**ADC Planning Consultation
Conservation/Design Officer Response**

Application Number	Y/34/17/HH
Address	Forge Cottage, Church Road, Yapton
Description	Alteration and addition to a building with a designated area
Case Officer	Simon Davis
Date	21 June 2017

Title
NORTH & EAST ELEVATIONS
AS PROPOSED

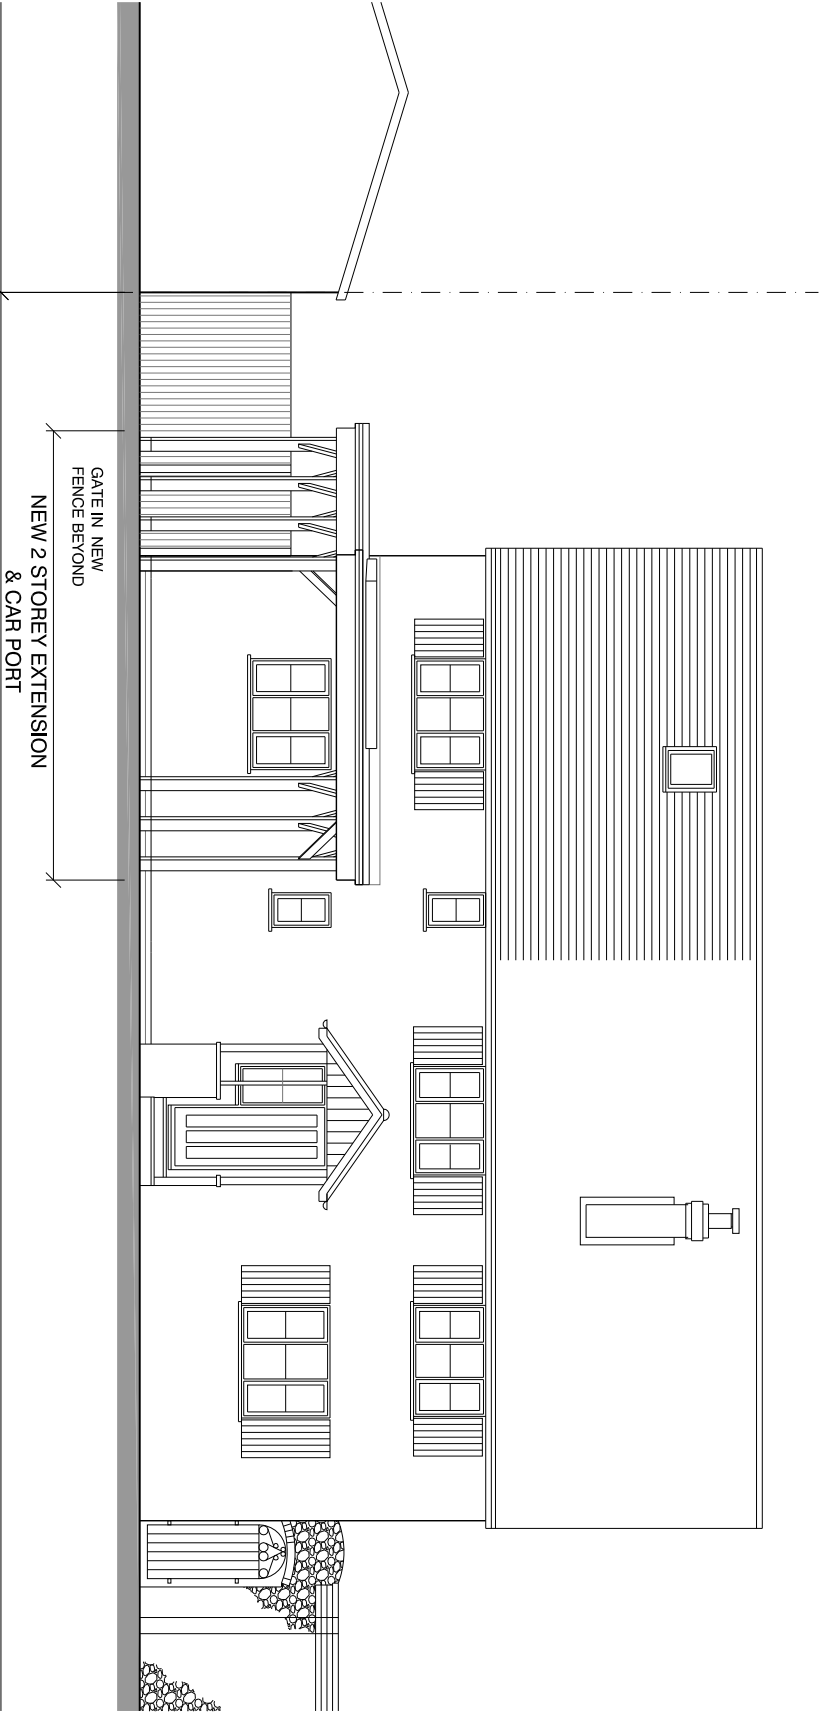
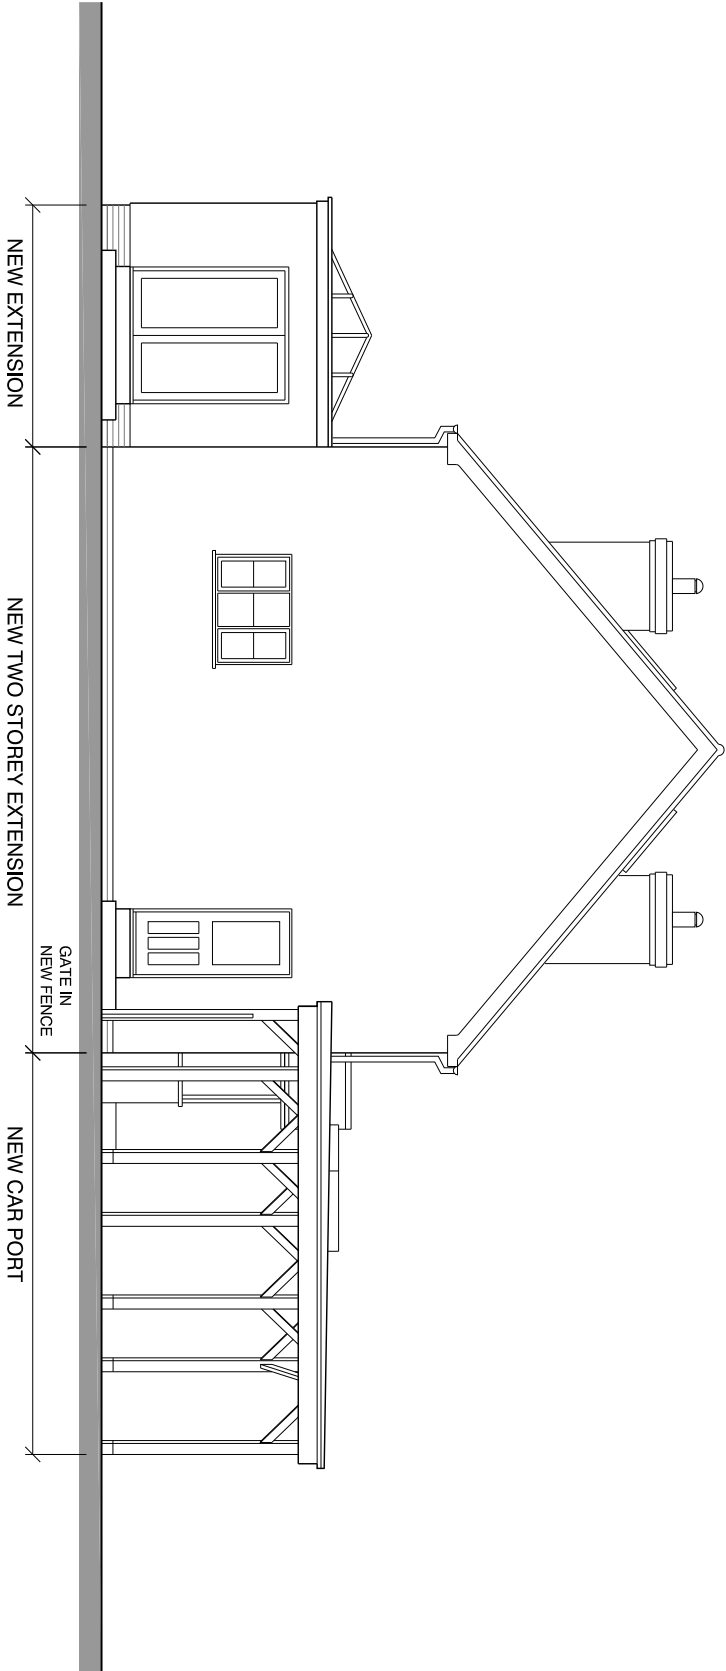
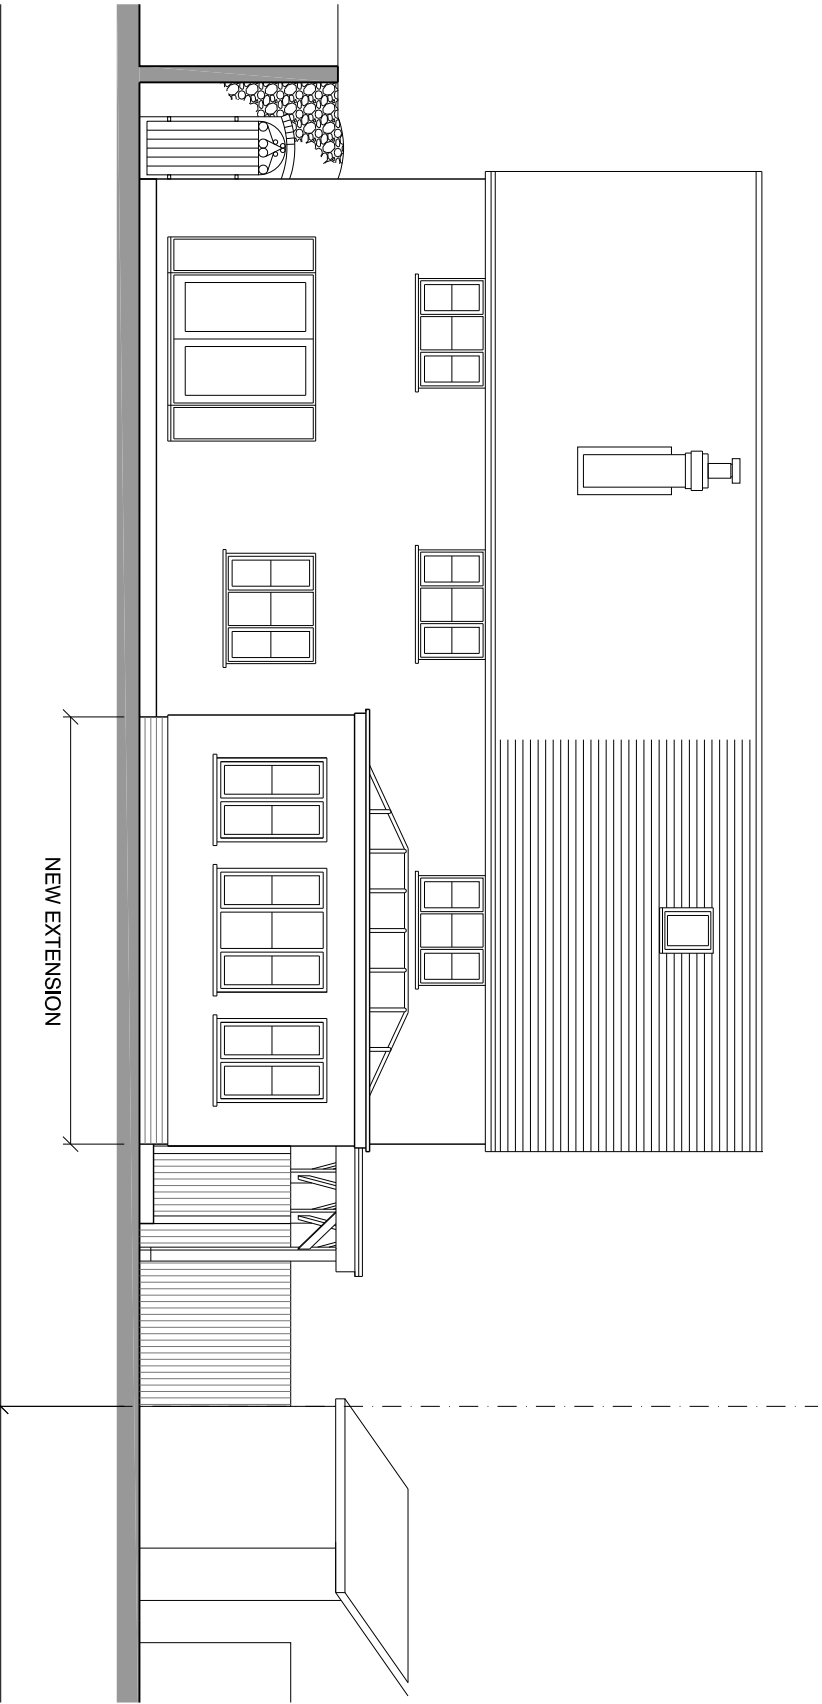
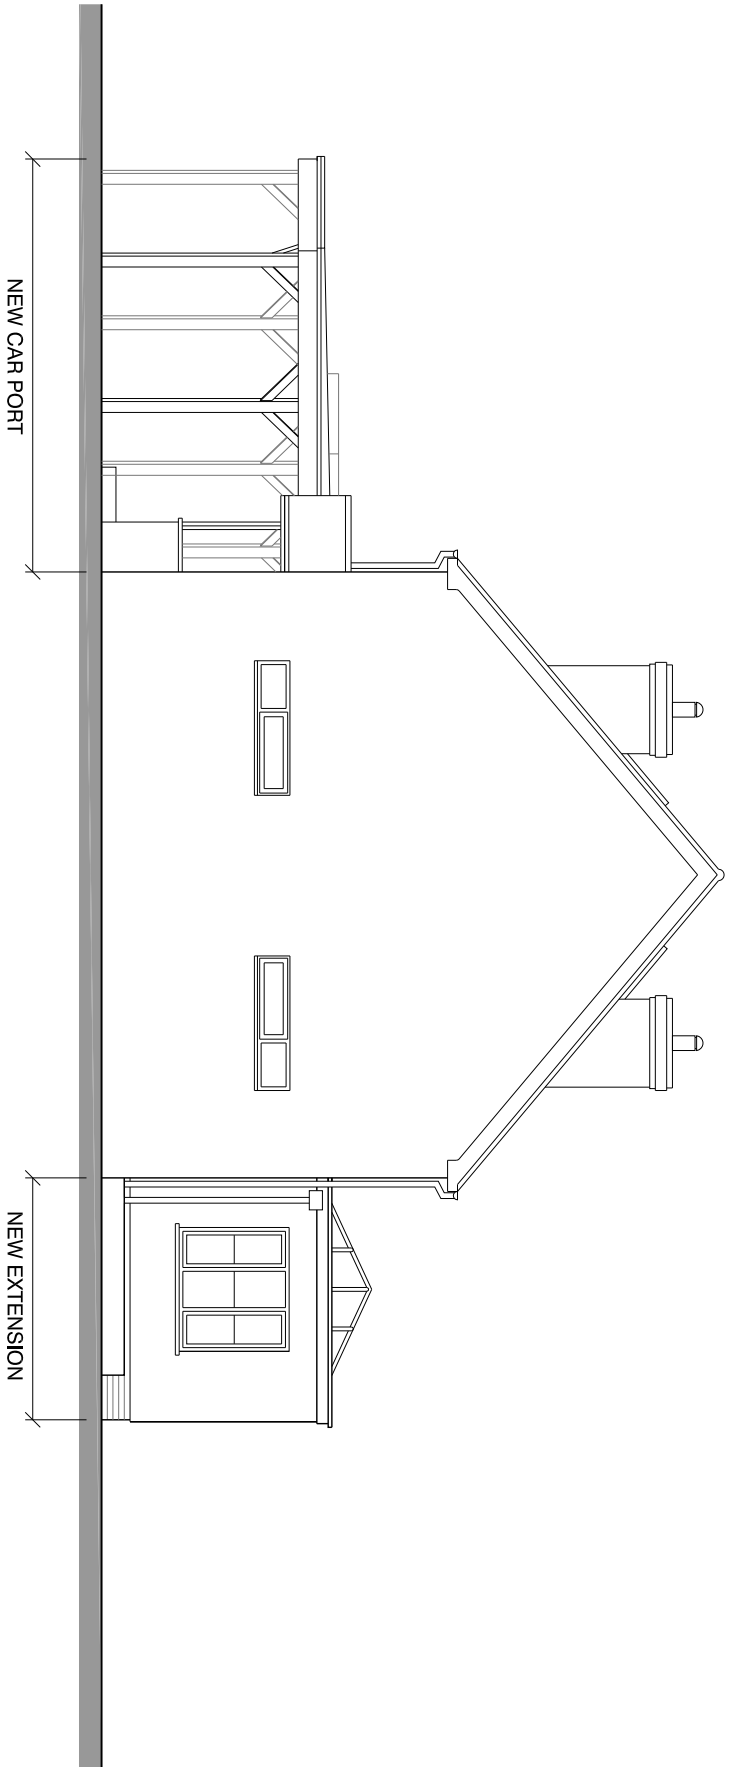
From the conservation perspective, it is rarely considered appropriate to significantly alter the principal elevation of a building within a designated area. Distinctive architectural qualities are likely to be obscured and the building's special contribution to local character diminished. However in this case, the host dwelling occupies a 'backland' location and it has little visual presence in any important streetscapes. The building lacks evident architectural merit and it makes a limited contribution to the distinctive qualities of the conservation area.

The two storey addition is a dominant, bulky element which transforms the appearance of the host dwelling and considerably intensifies the present level of development on the site. However, the enlarged built form remains reasonably consistent with the scale of adjacent buildings and it continues to have little presence in the public realm.

While the proposal is not entirely consistent with para 137 of the NPPF - which requires new development to *enhance or better reveal* the significance of a designated area - it makes little difference to the overall appearance of the host building, which remains neutral.

The impact of the proposal on the significance of the designated area is therefore negligible. Although it fails to contribute anything positive, it causes little actual harm, and it is condoned in terms of Local Plan 2003 Policy Area 2 and Local Plan 2014 Policy HER DM3.
